# **COUNTY COUNCIL'S RESPONSE TO CONSULTATION ON THE FOLLOWING DEVELOPMENT PROPOSAL**

**Application No:** 20/03353/OUT-2

**Proposal:** Outline application for a food store, including access and scale (resubmission of 20/00123/OUT)

**Location:** Land West of Cotefield Business Park Oxford Road Bodicote

Permeable Car Park External

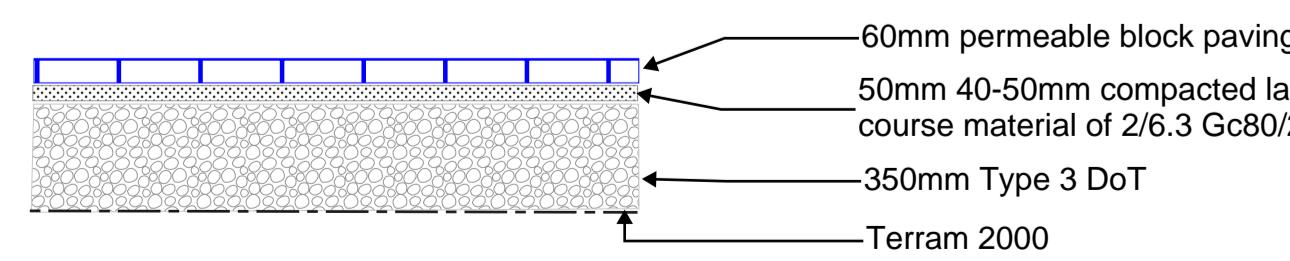
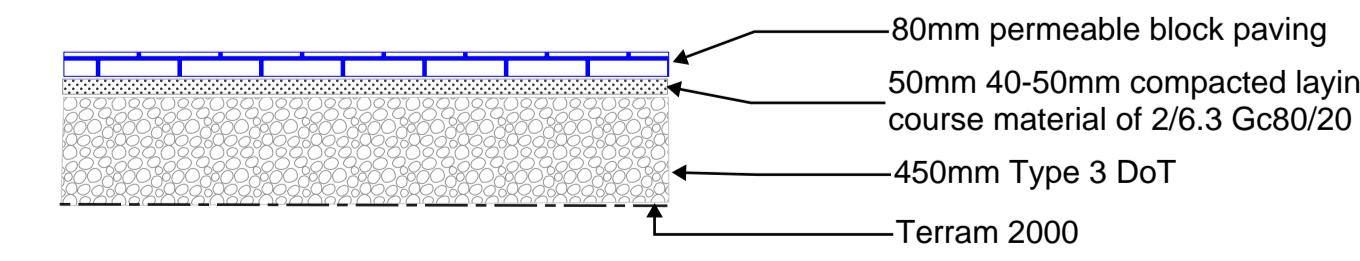
Proposed permeable paving solution must be proven to be a good measure of water quality measure by using water quality assessment in accordance with CIRIA SuDS Manual.

SURFACE WATER
DRAINAGE STRATEGY

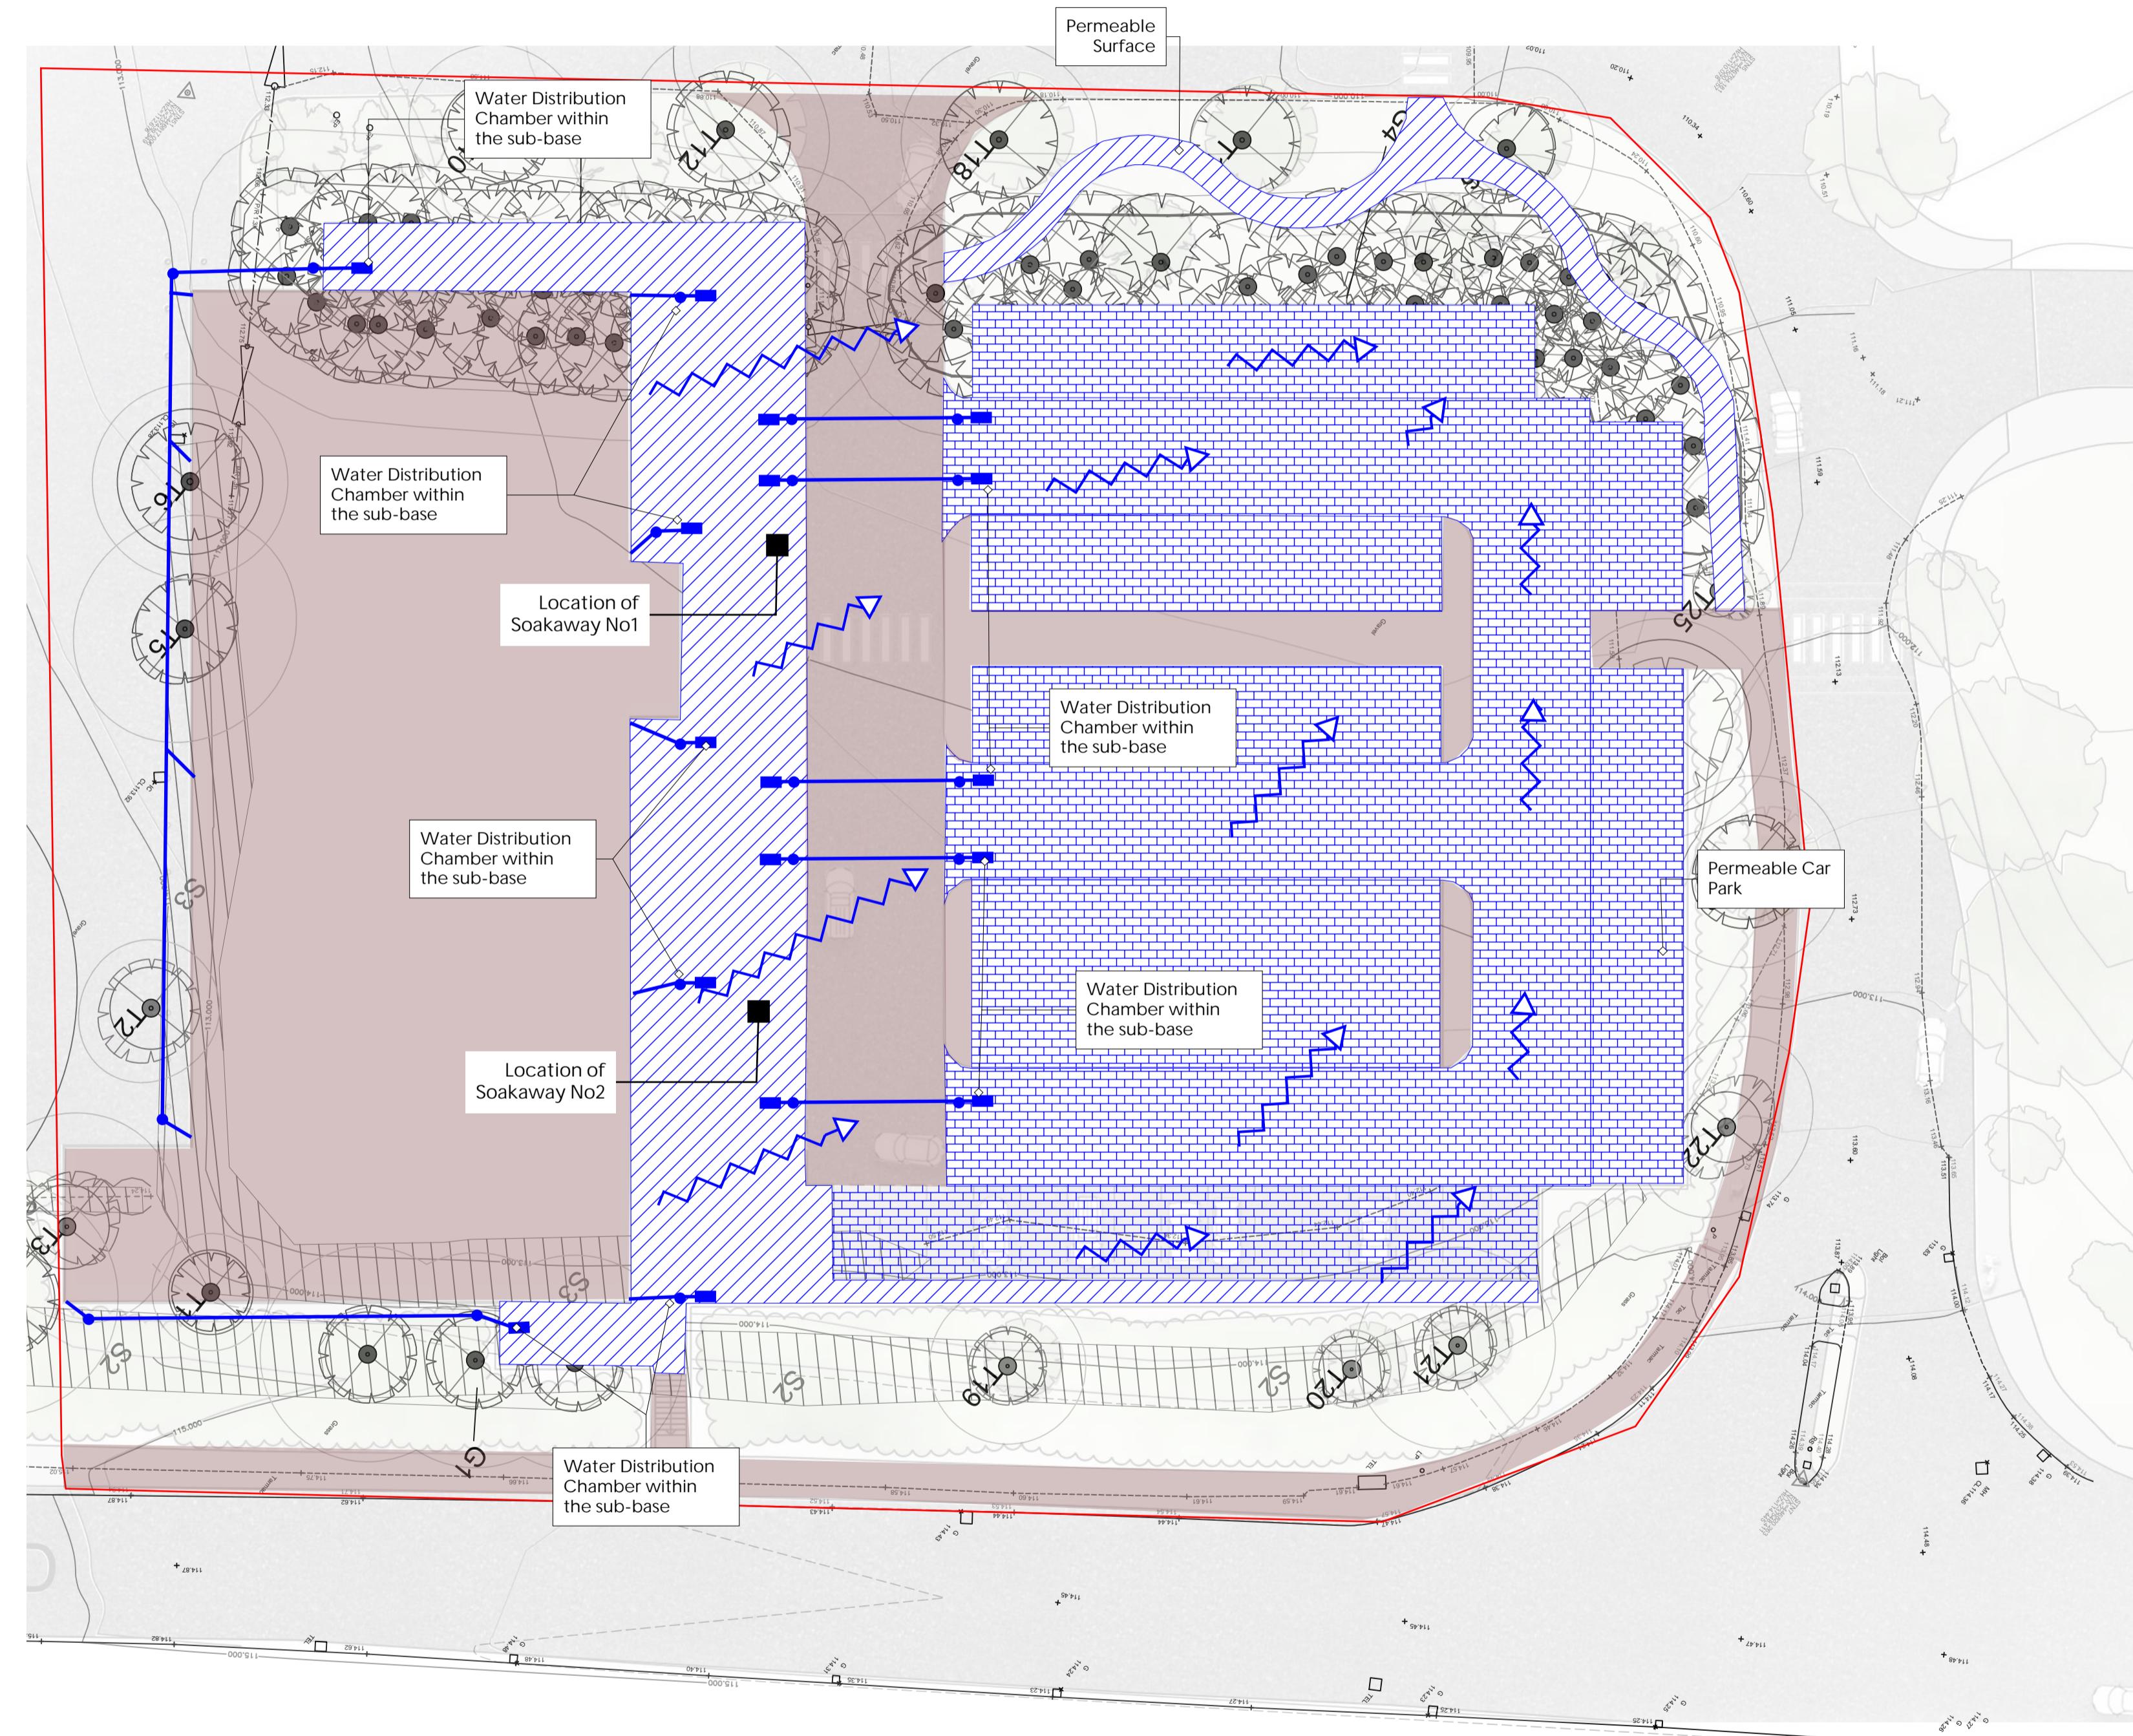
Applicant has stated there's an enclosed updated drainage layout showing location of soakaways, sub-base of the car park and more details of the drainage system. This drawing is nowhere to be found.

The applicant's proposal includes proposed car parking spaces, therefore reducing the water quality being discharged. Water Quality standards must be met. Proposed development needs a water quality assessment in accordance with Section 4 and Section 26 of SuDS Manual.

Proposed development must meet local standards, L19, "At least one surface feature should be deployed within the drainage system for water quality purposes, or more features for runoff which may contain higher levels of pollutants in accordance with the CIRIA SuDS Manual C753. Only if surface features are demonstrated as not viable, then approved proprietary engineered pollution control features such as vortex separators, serviceable/ replaceable filter screens, or pollution interceptors may be used"
